East Anglia One North (EA1N) and East Anglia Two (EA2) Offshore Wind Farms

Planning Inspectorate Reference: EA1N – EN010077, EA2 – EN010078

Deadline 8 – 25 March 2021

Comments of Suffolk County Council as Local Highways Authority

DRAWING No TP-PB4842-DR007 REVISION

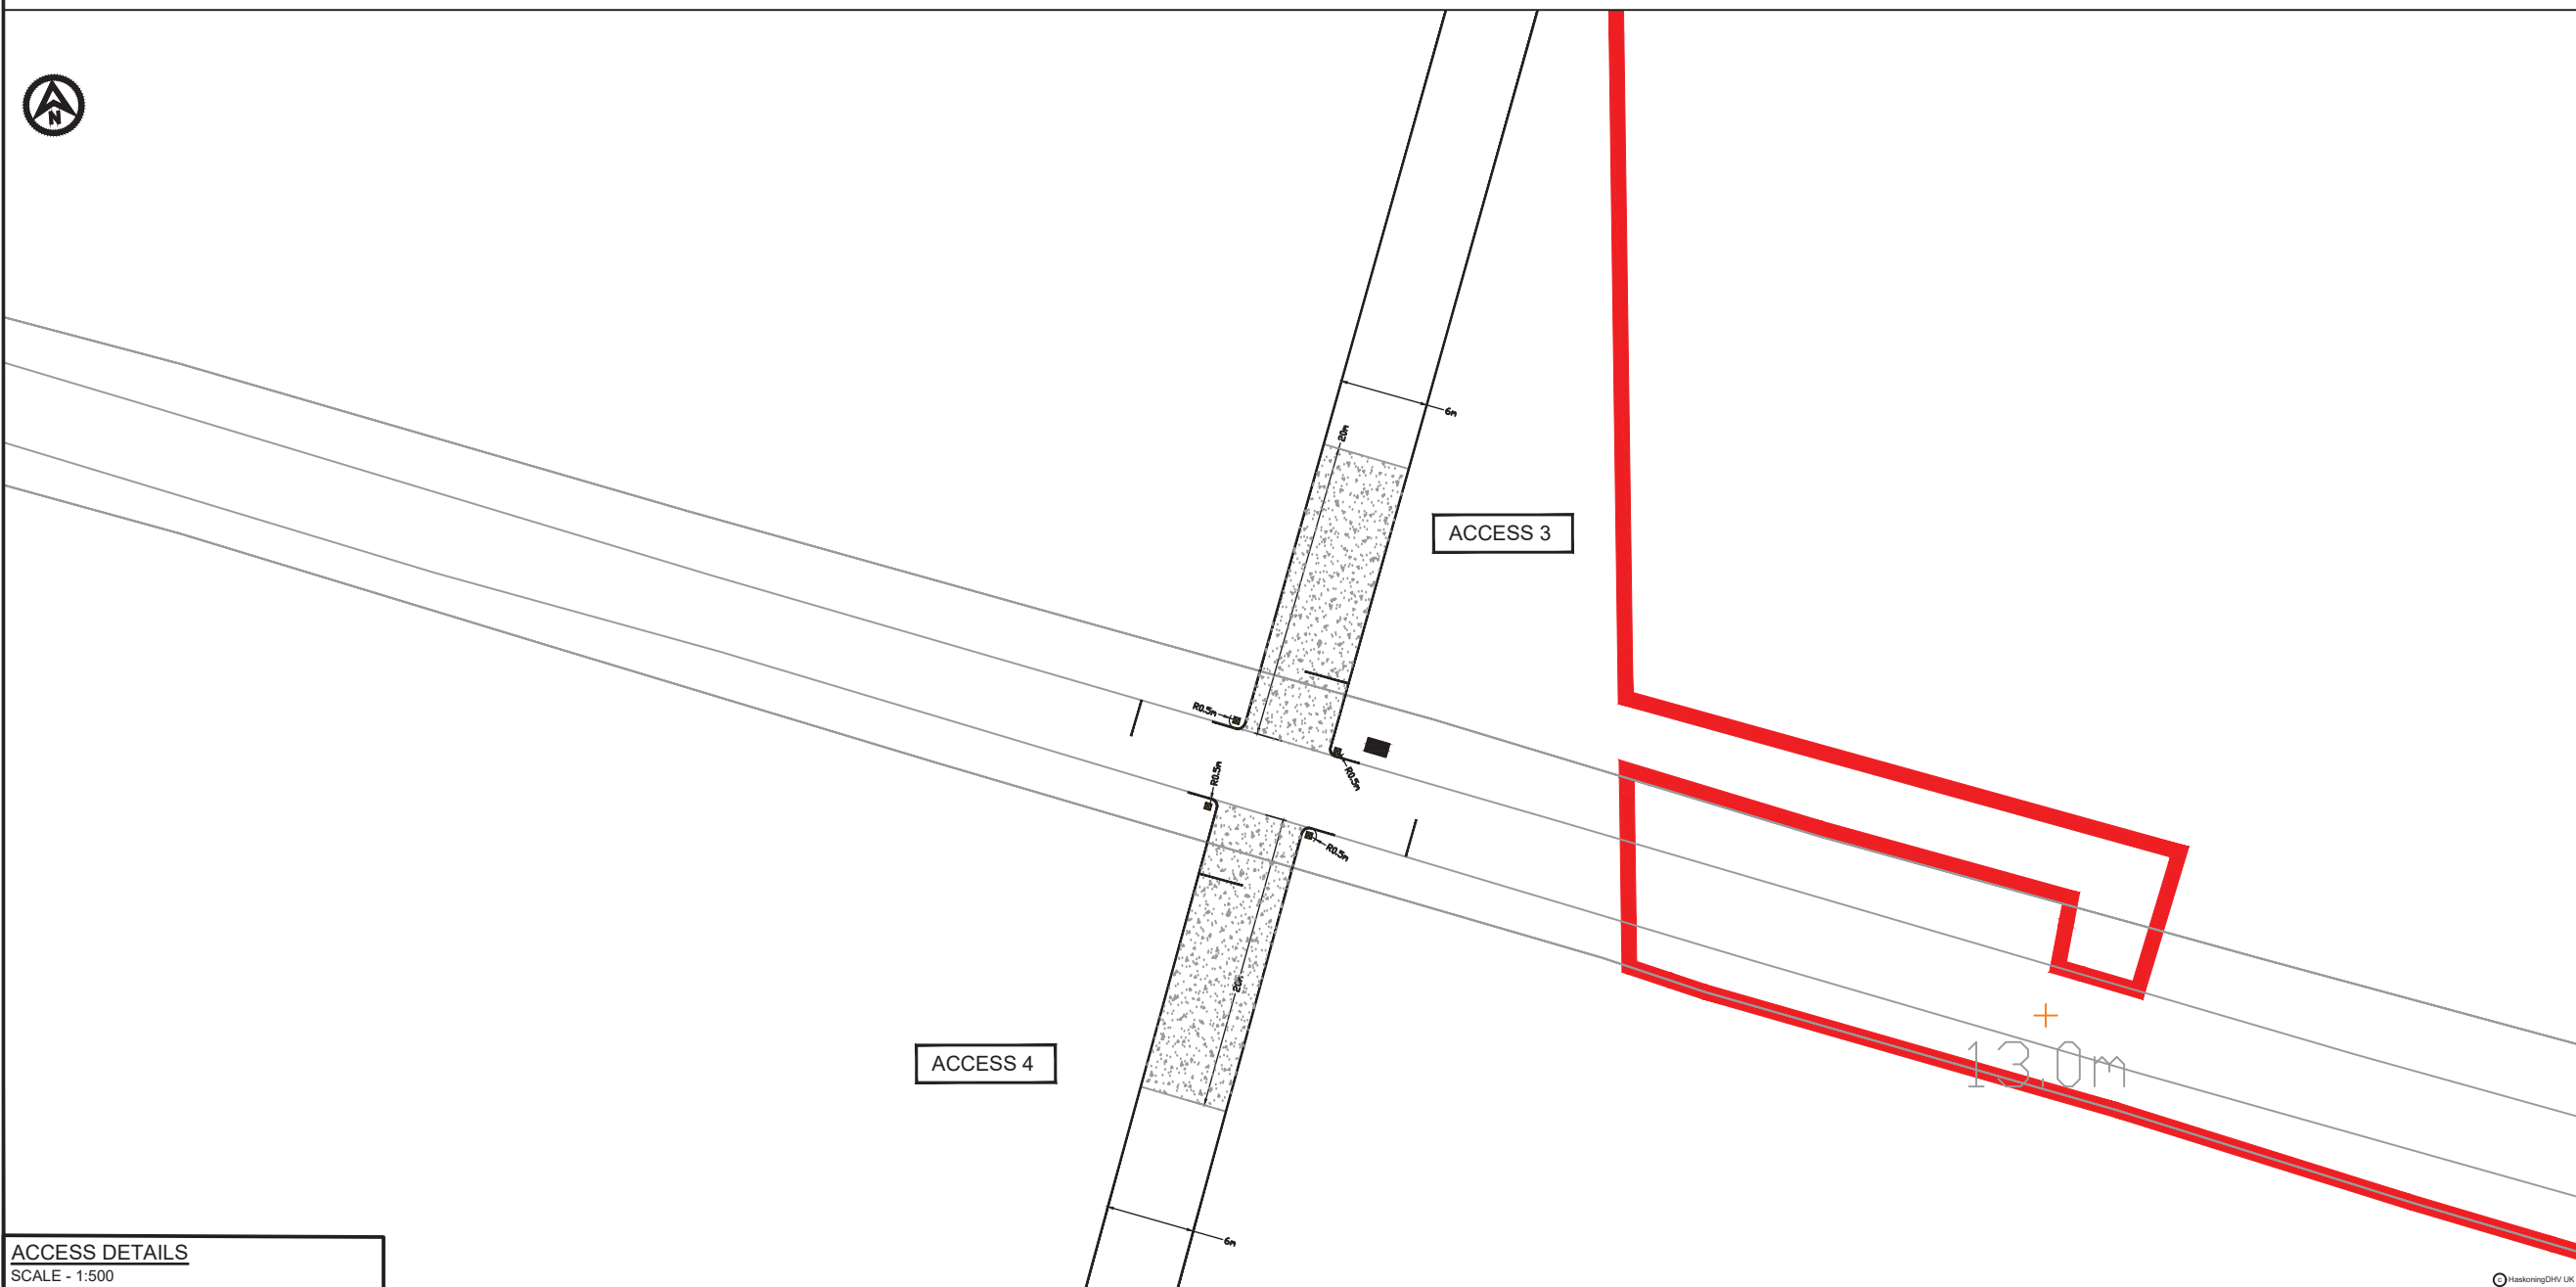
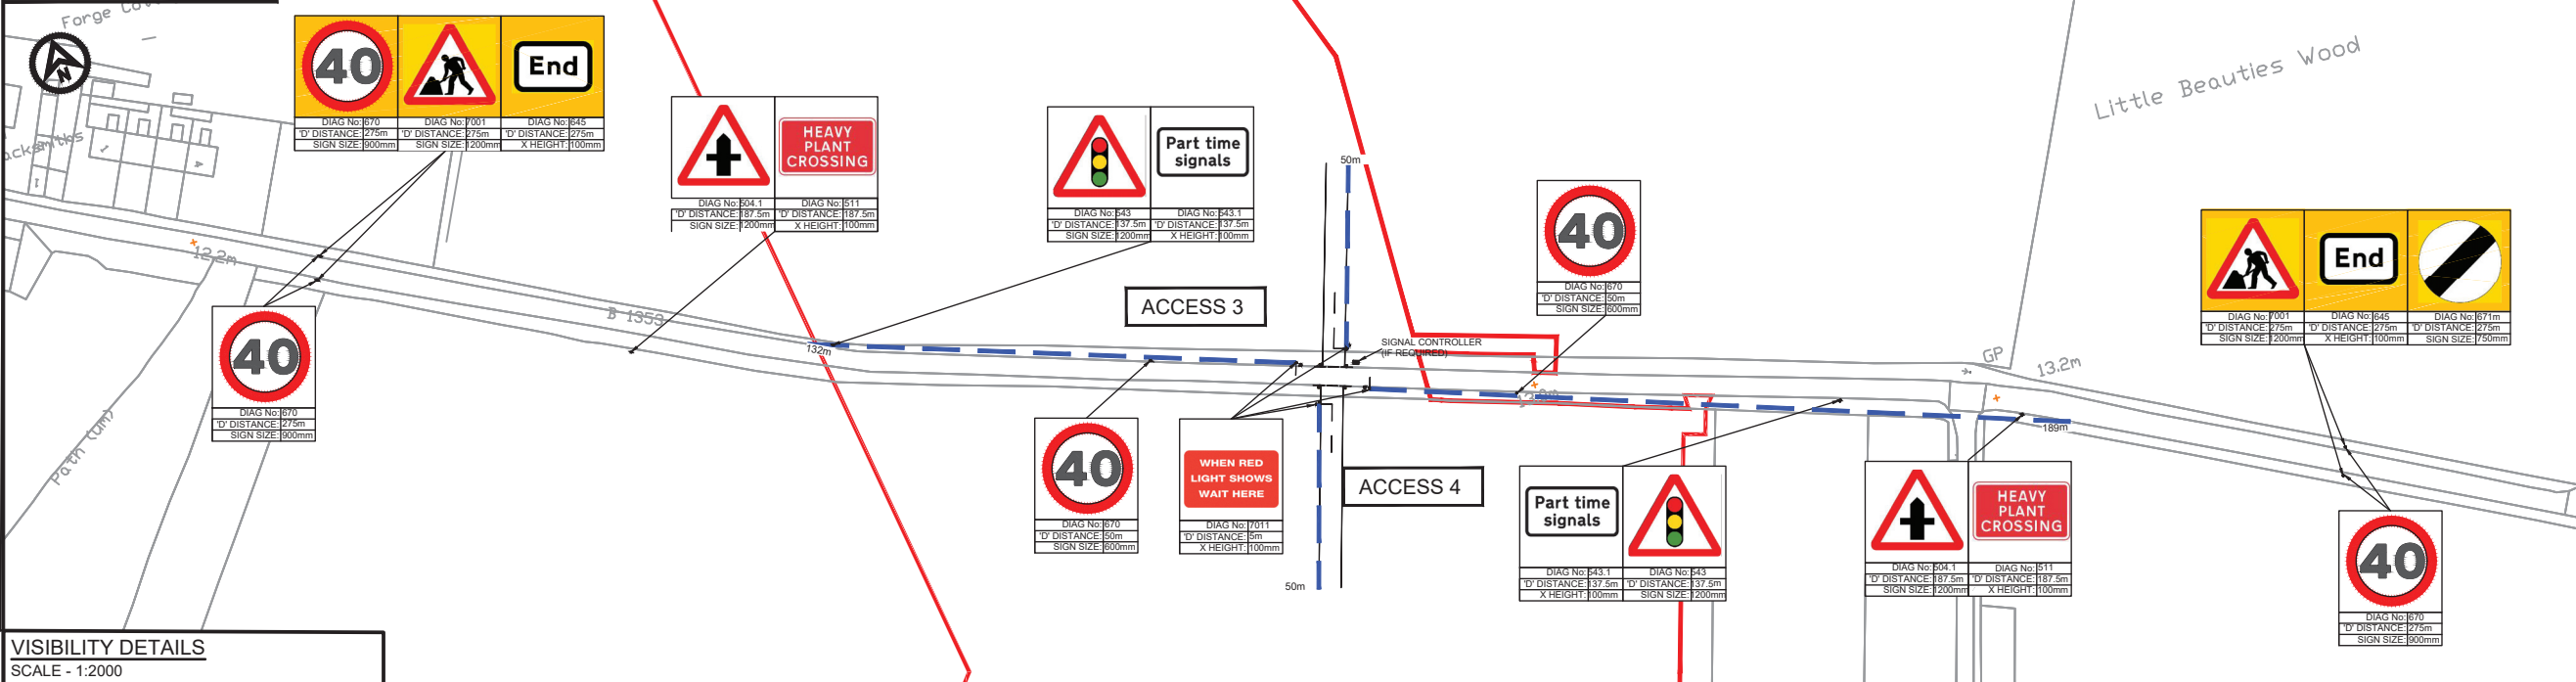
The LHA **accepts** the proposals for a crossing point on the B1353 (drawing TP-PB4842-PR007 Rev D0.5 REP6-010) and considers it a preferable solution than providing an access. The visibility for construction approaching the crossing needs to be confirmed and shown on the drawing. As part of any agreement with the LHA there will be a requirement to monitor the crossing and for the Applicant to undertake any actions the LHA considers necessary to maintain and operate this safely.
